Grazing Yak Solar

SITE DEVELOPMENT PLAN

Civil Construction Plans - Issued For Site Development Plan

SHEET: C.200

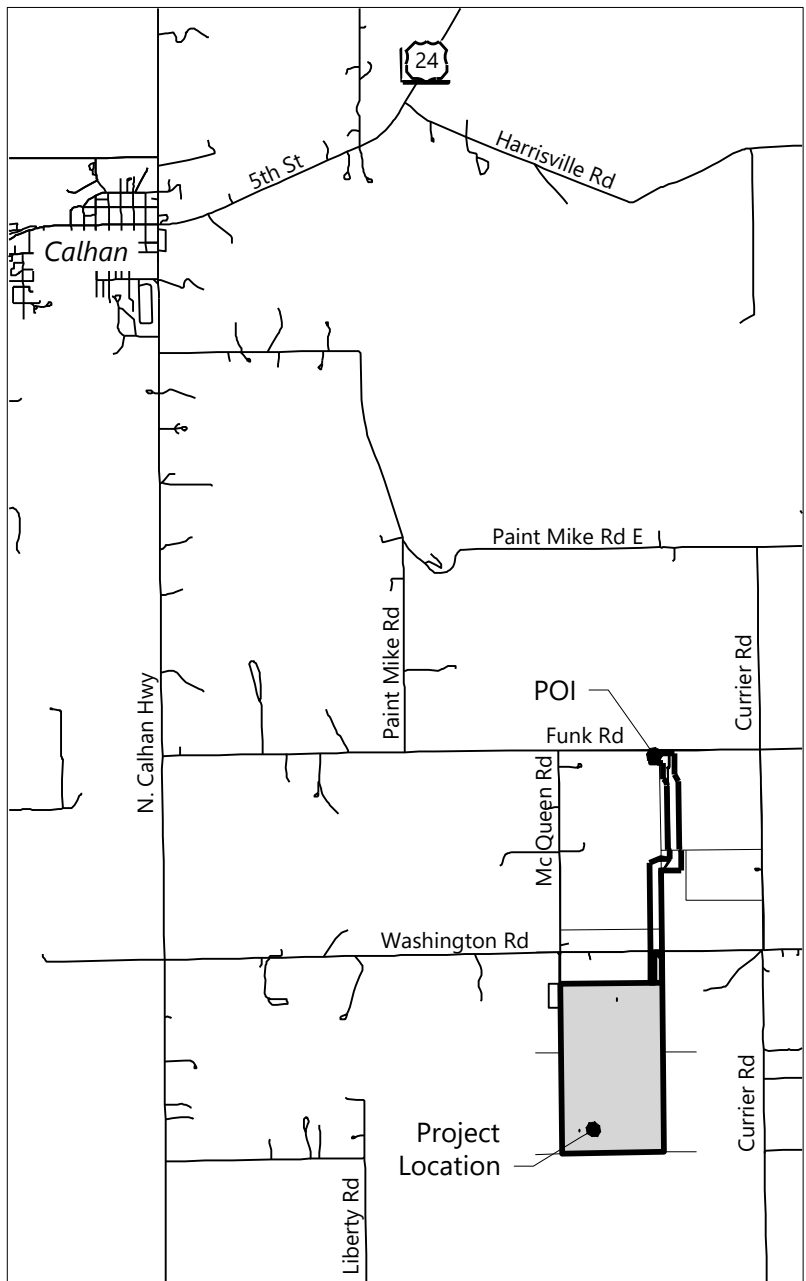
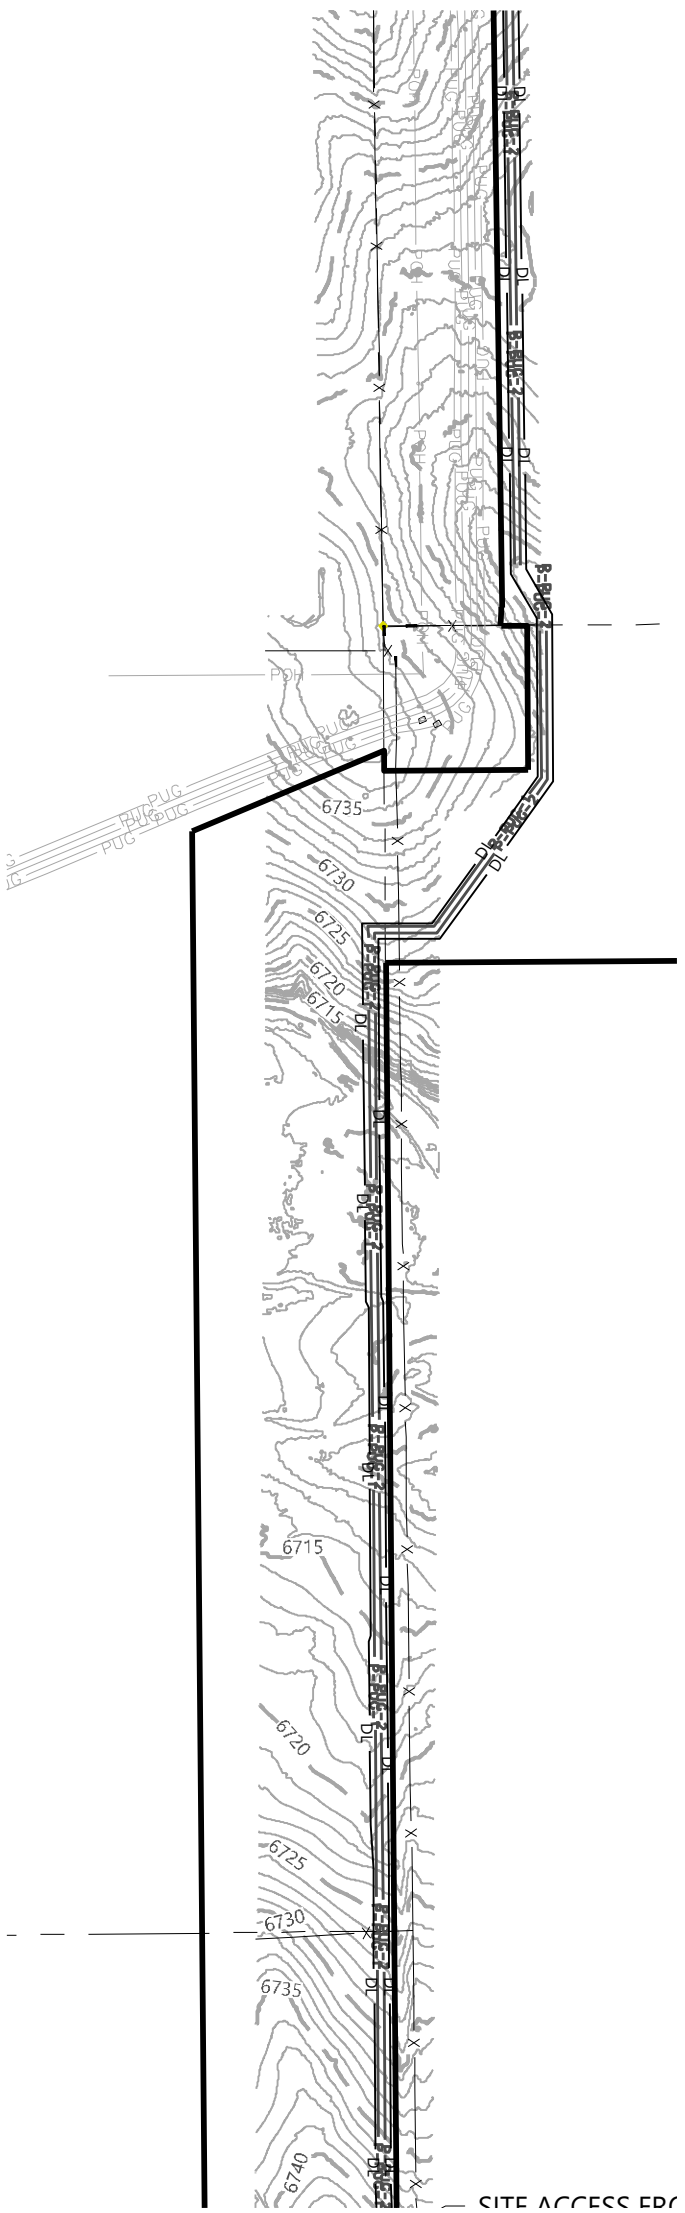
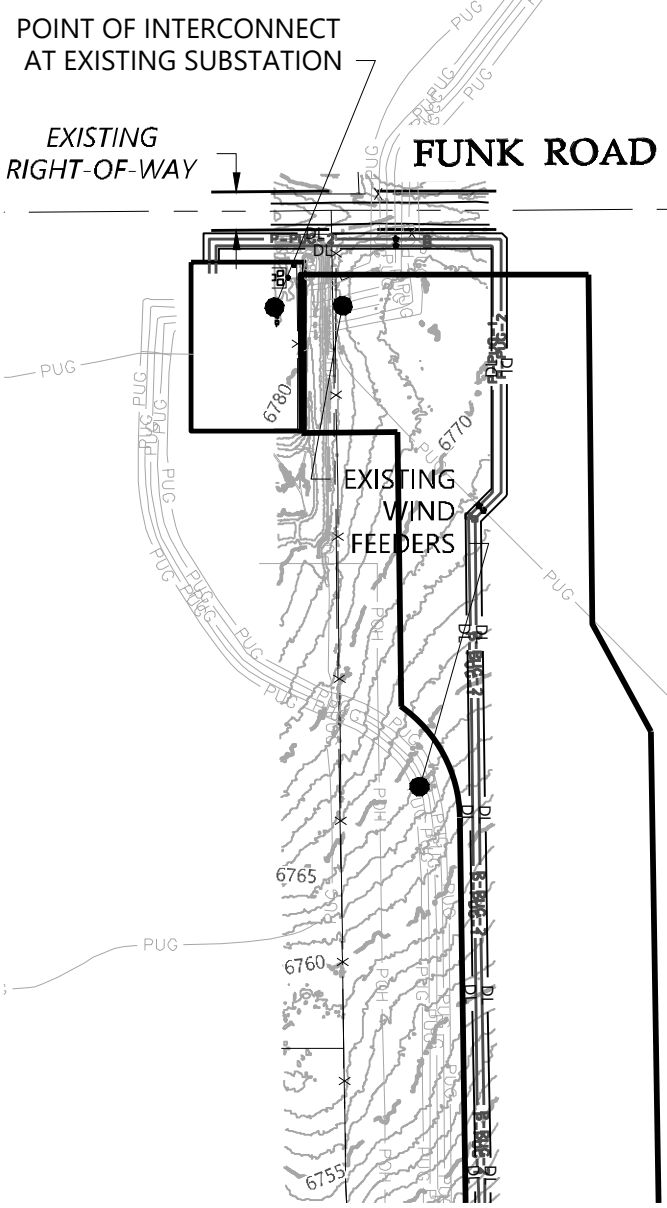
this should be in Feet to match the WSEO dimensional standrds
